Recommendation Report for Planning Permission**REF NO:** R/225/13/**LOCATION:** Sainsburys Supermarkets Ltd, Unit C
New Road
Rustington Littlehampton**PROPOSAL:** Installation of transformer, generator, substation, sprinkler tank and pump house at ground floor level along with rooftop condenser units.**SITE AND SURROUNDINGS**

RECOMMENDATION

REFUSE

DRAWING
Proposed Roof Plant

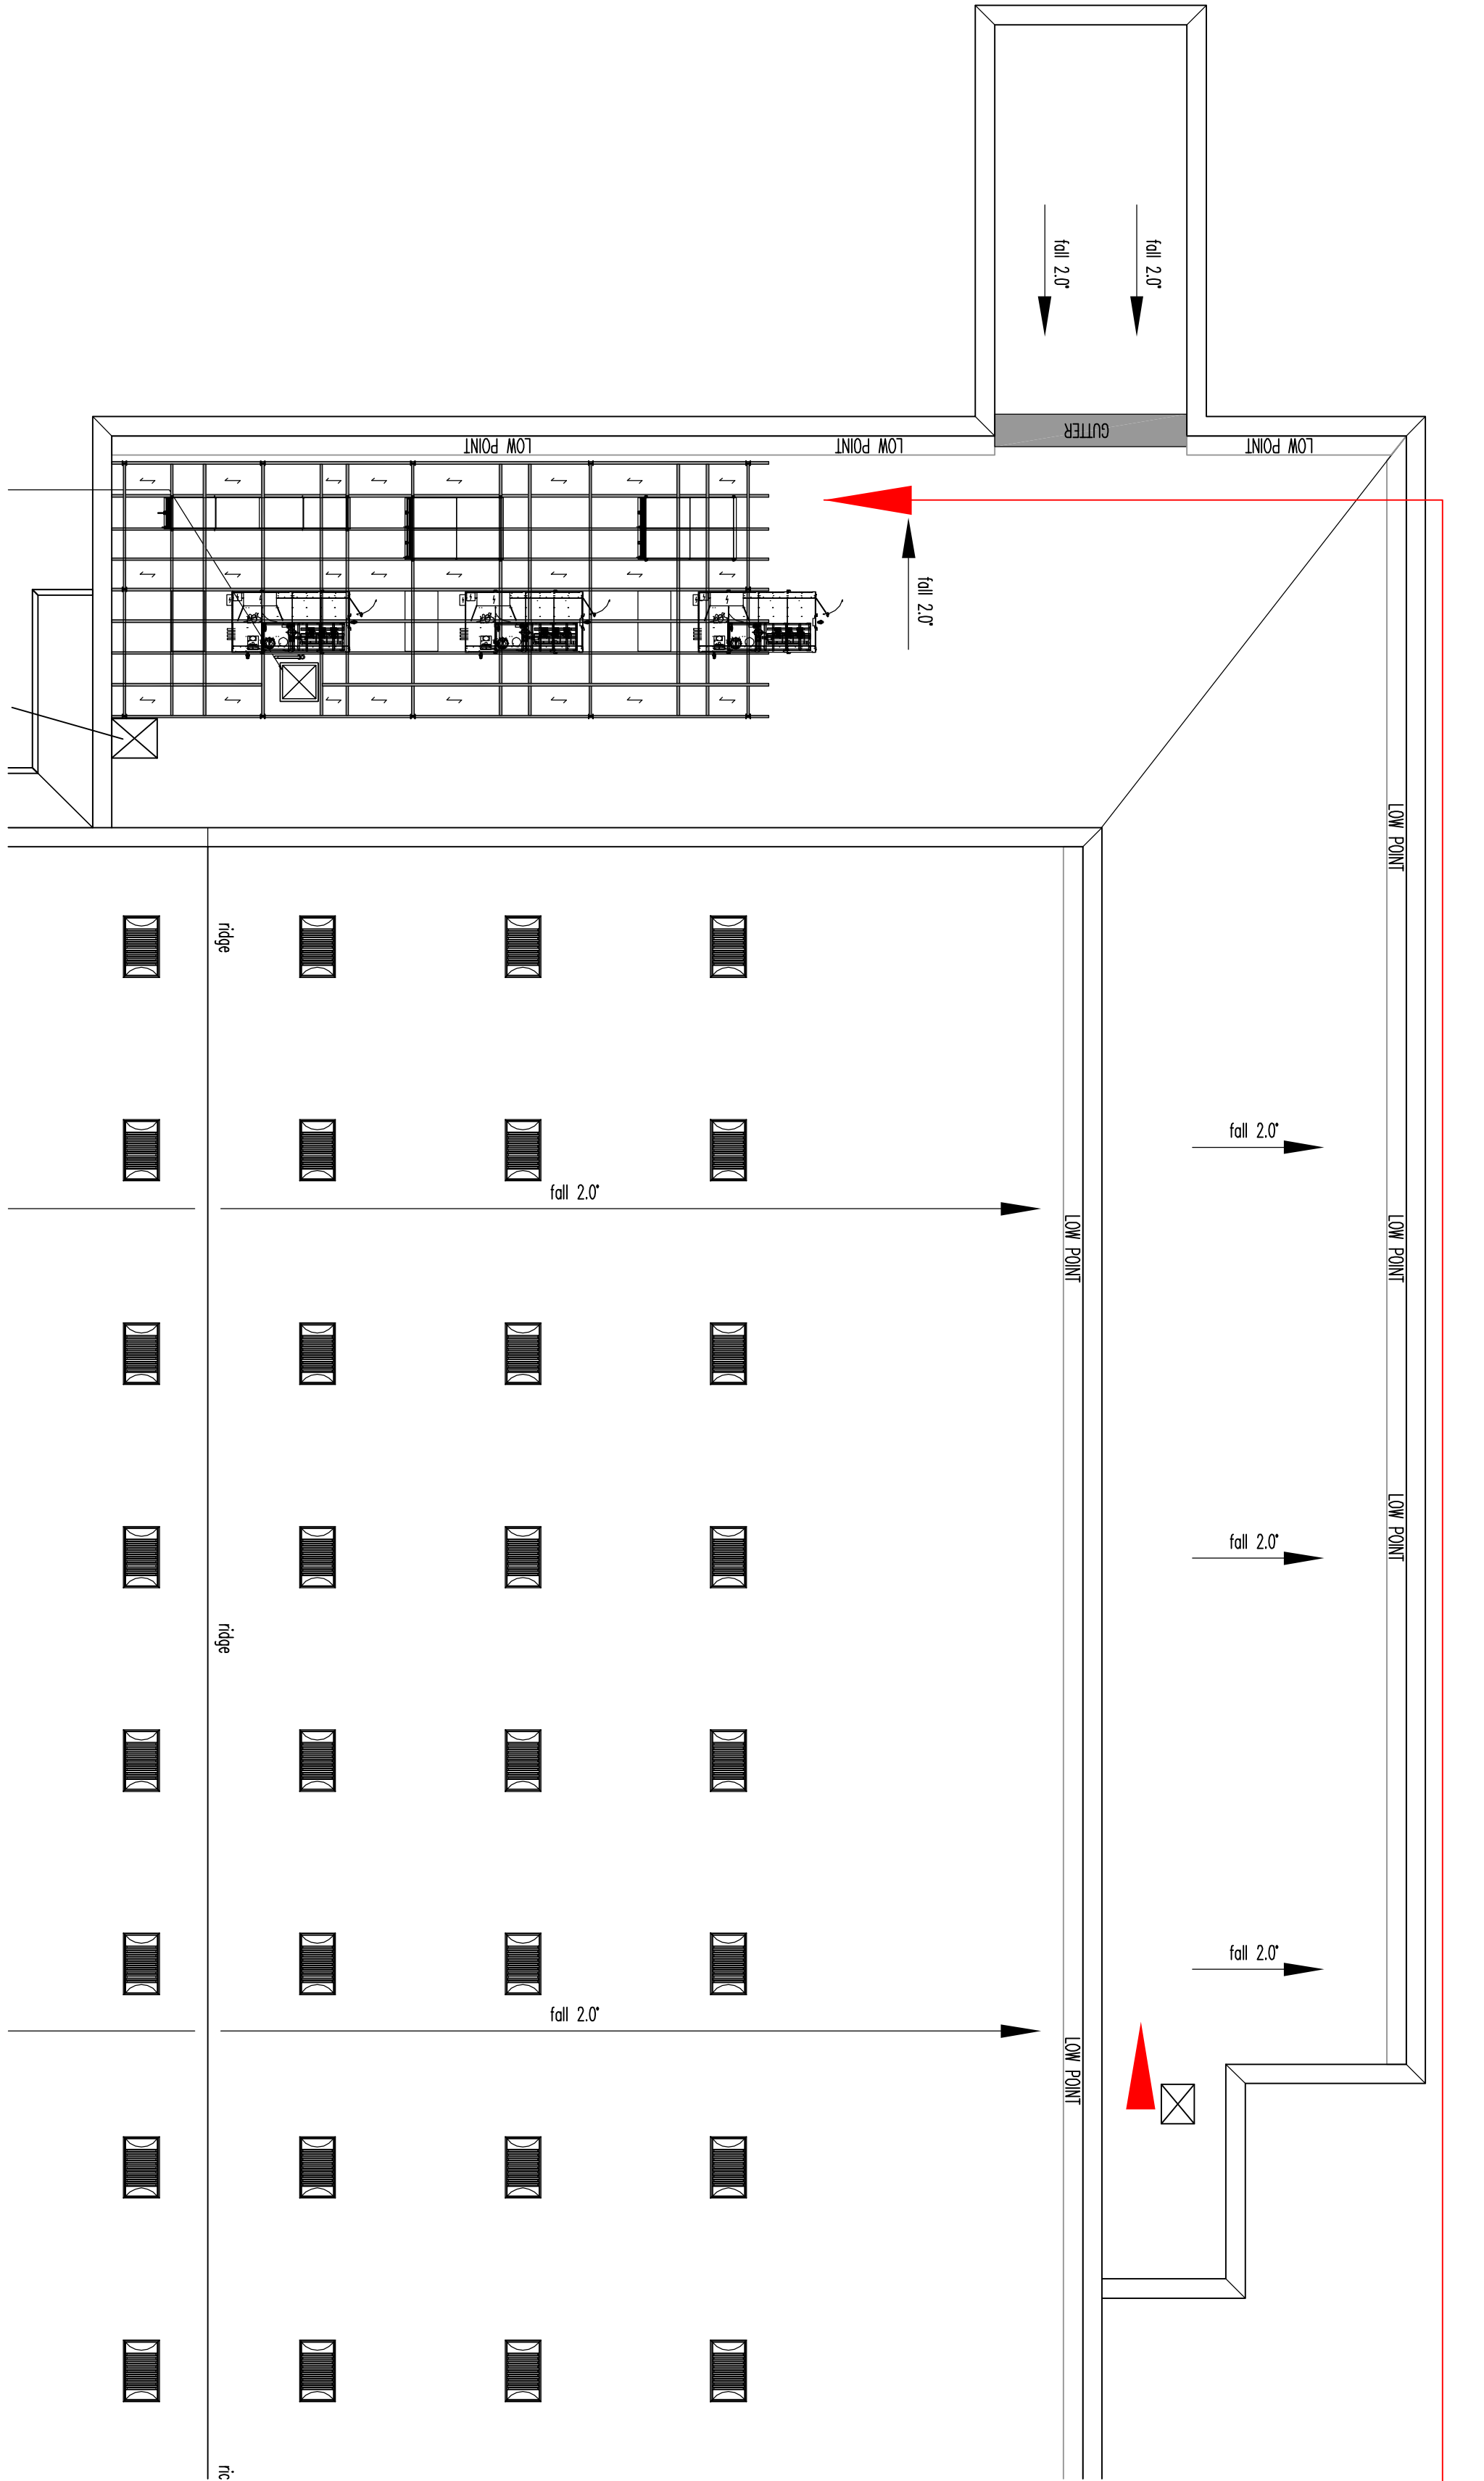
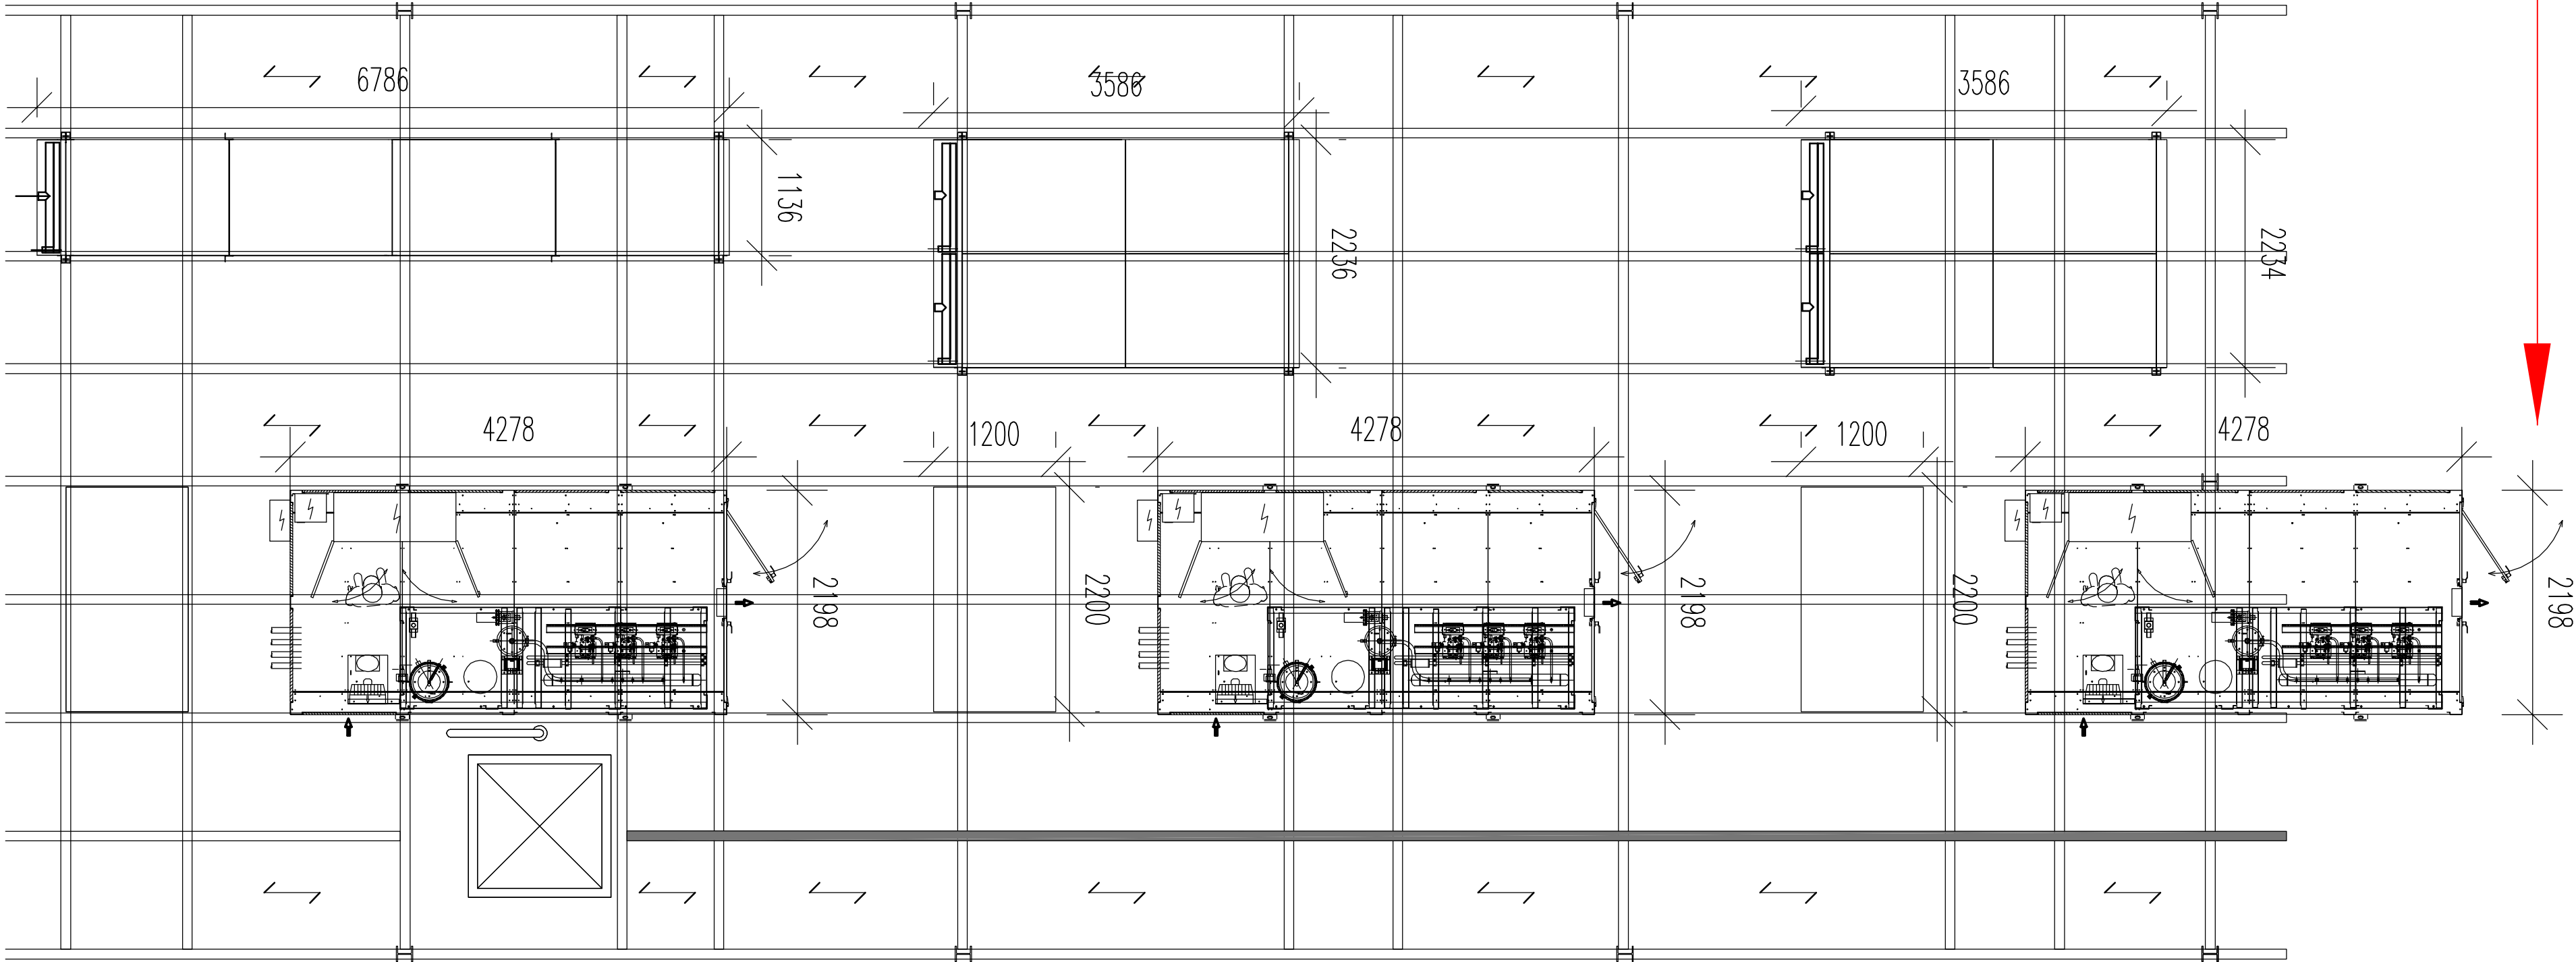
The proposed condensers are approximately 1.2 metres tall and will be grey metal in appearance. The proposals are located on the eastern end of the flat roof section to the rear and east of the site

The Environmental Health Officer's response highlights that confirms that noise from proposed plant will be below the lowest measured existing background "target levels" derived from BS 4142 at the nearest existing residential receptors, subject to the provision of noise attenuation measures proposed within the report.

The condenser units are located on the eastern end of the flat roof section to the rear and east of the site, and are not immediately visible from the surrounding public realm and as such is not likely to have a significant impact on visual amenity and the character of the area.
